Phone: 0300 123 6780
Email: developeras@lancashire.gov.uk
Your ref: 3/2026/0607
Our ref: D3/2026/0607
Date: 19 August 2026

Planning Application No: 3/2026/0607

Proposal: Conversion of storage building to two bedroom single storey dwelling and garage.

Location: Land at George Street, Longridge PR3 3JS

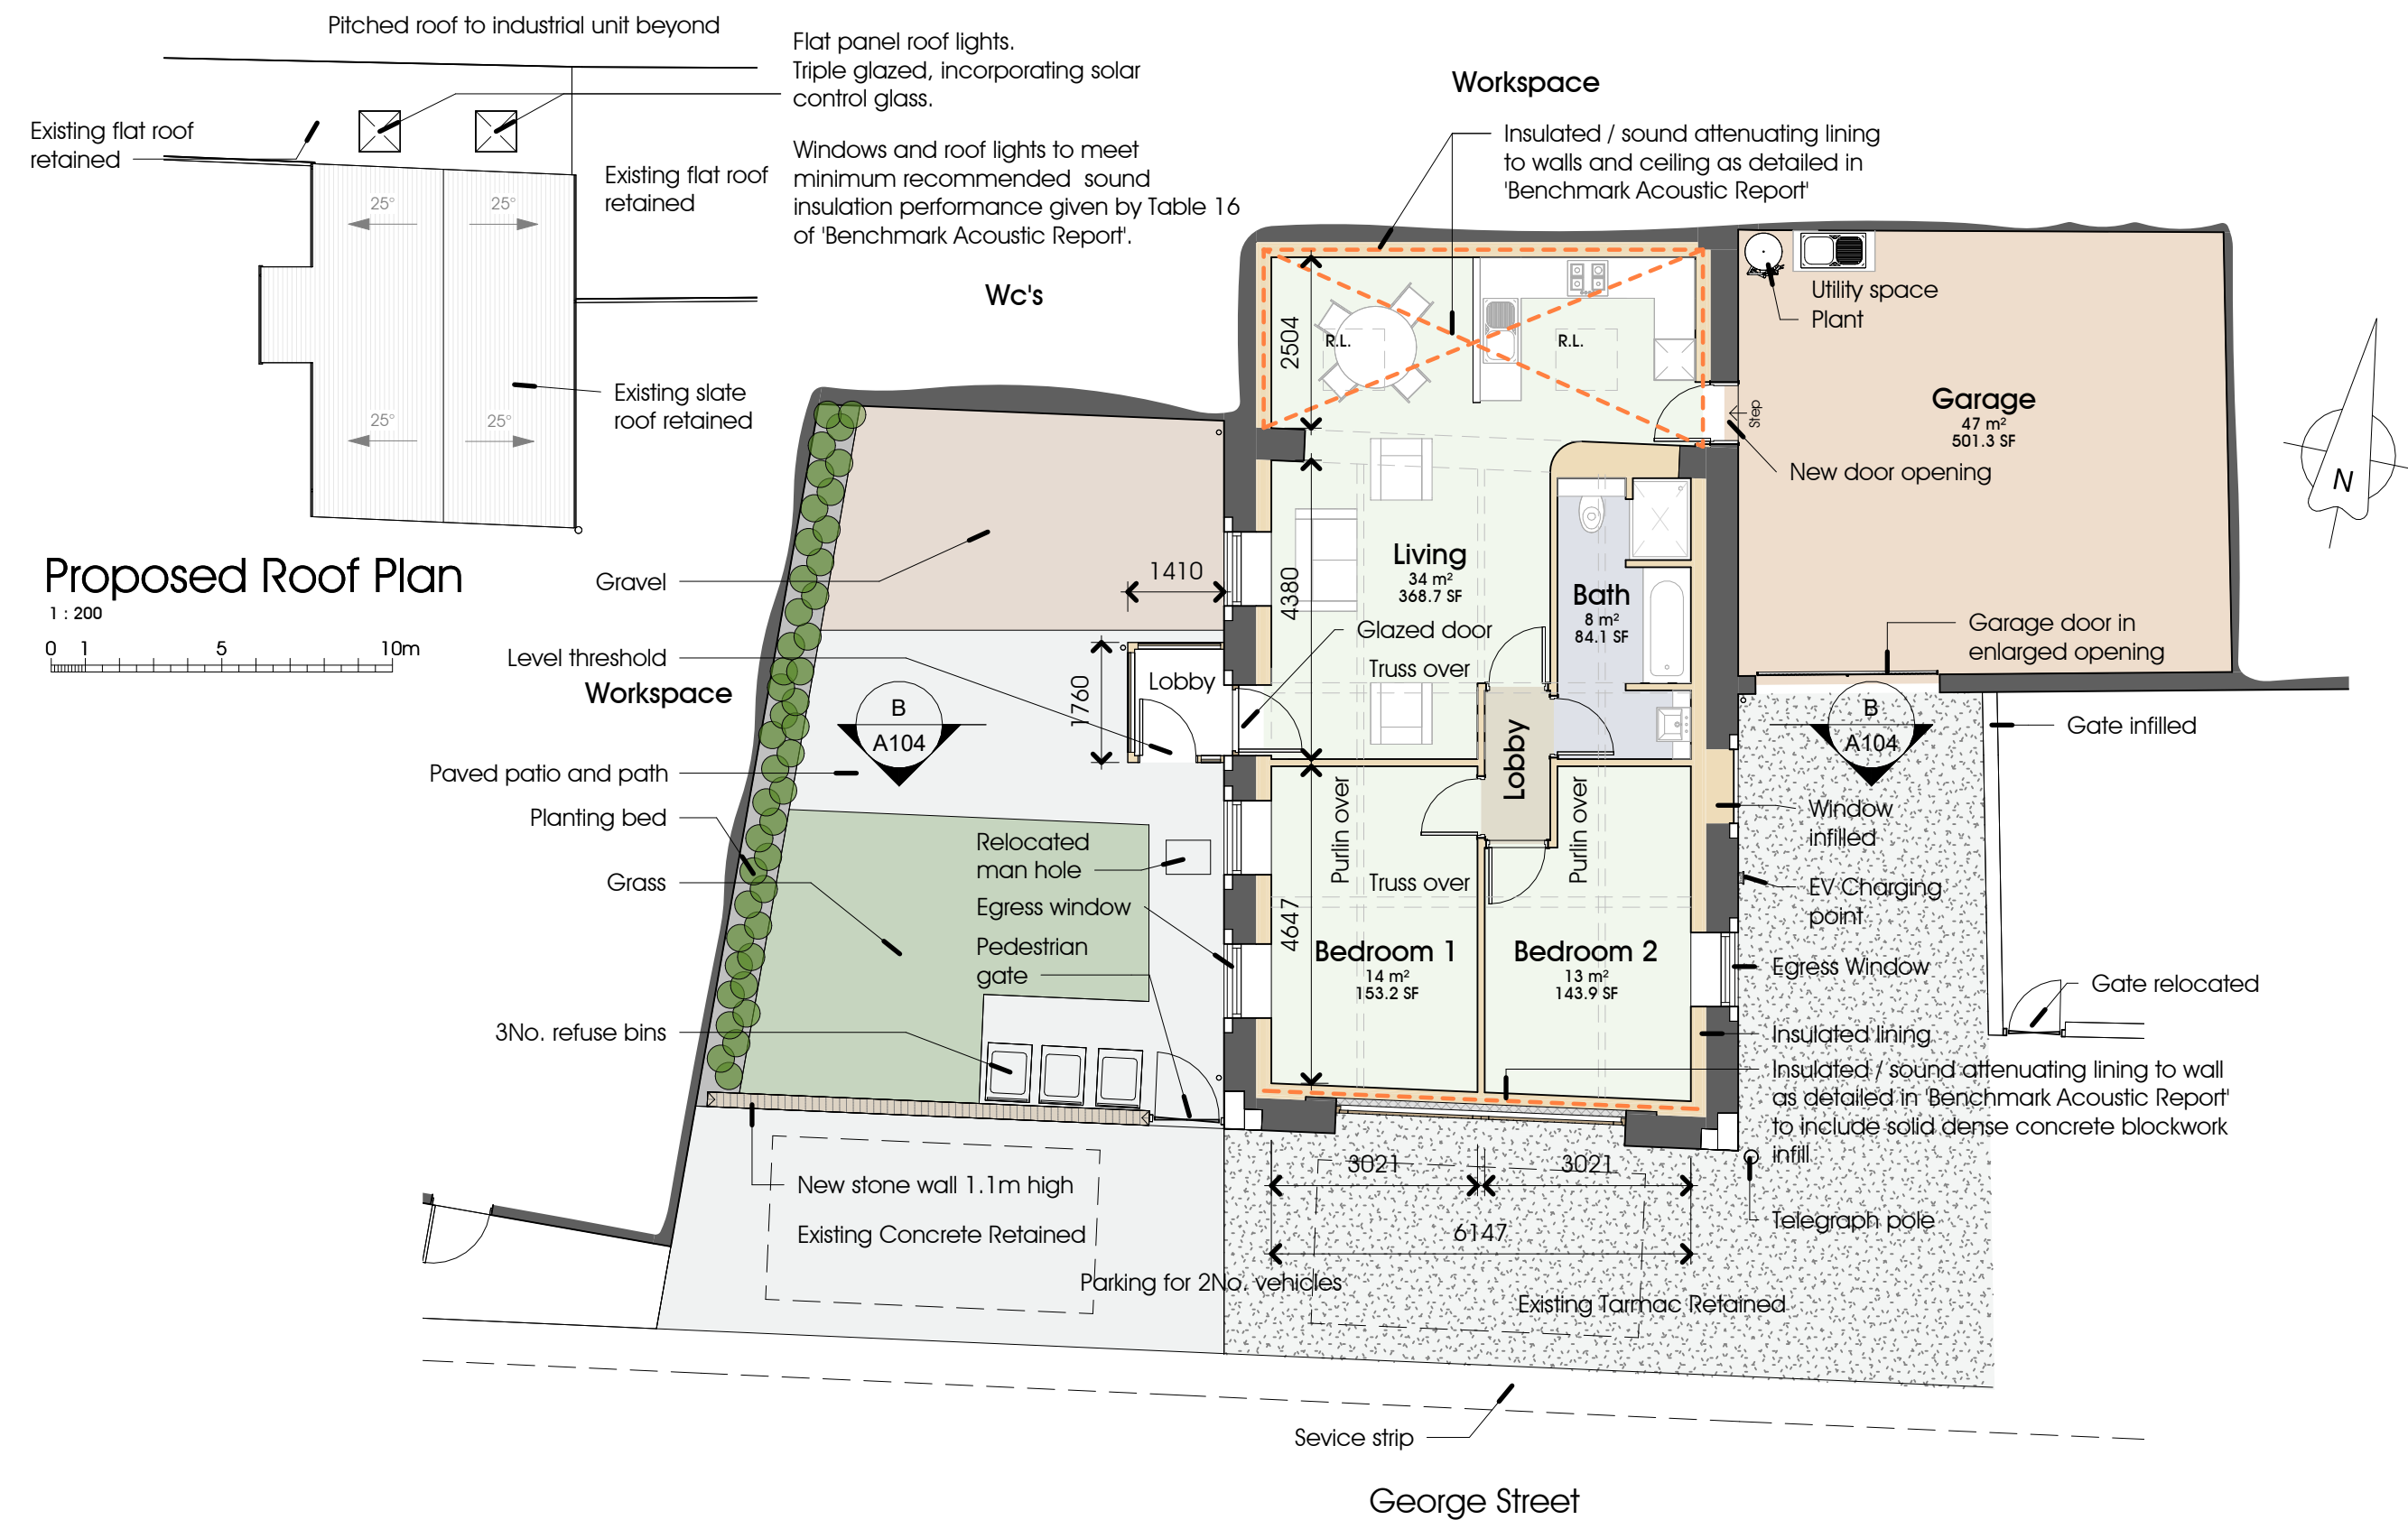
The highway authority would expect two adequately sized off-road car parking spaces to be provided for a dwelling with two bedrooms. The proposed garage is considered adequately sized internally to provide one car parking space, plus secure cycle storage. A further parking space can be provided on the driveway in front of the garage. Two further spaces are indicated across the front of the site. Whilst there may be adequate visibility for a driver exiting the space in front of the dwelling's gable end, visibility from the second space could be obstructed by the adjacent red brick building.

As the electric vehicle charging point is proposed to be mounted on an external wall and not provided within the garage this should be fitted in line with the Dept for Transport's guidance regarding Electric Vehicle Charging in Residential and Non-residential Buildings. This states that charge points must have a minimum power rating output of 7kW and be fitted with a universal socket that can charge all types of electric vehicles. This can be controlled by condition.

To ensure that adequate car and cycle parking is retained on site the highway authority requests that this is controlled by a separate condition to protect future parking provision.

1. The parking areas including garage hereby approved shall be kept available for the parking of vehicles ancillary to the enjoyment of the household and shall not be used for any use that would preclude the ability of their use for the parking of private motor vehicles, whether or not permitted by the provisions of the Town and Country Planning (General Permitted Development) Order 2015 or any order amending or revoking and re-enacting that order. Reason: To ensure that adequate parking provision is retained on site.

2. Prior to first occupation of the approved development an electric vehicle charging point shall be provided in accordance with a scheme to be approved by the Local Planning Authority. Charge points must have a minimum power rating output of 7kW and be fitted with a universal socket that can charge all types of electric vehicle currently available. Reason: To ensure that the development supports sustainable forms of transport.
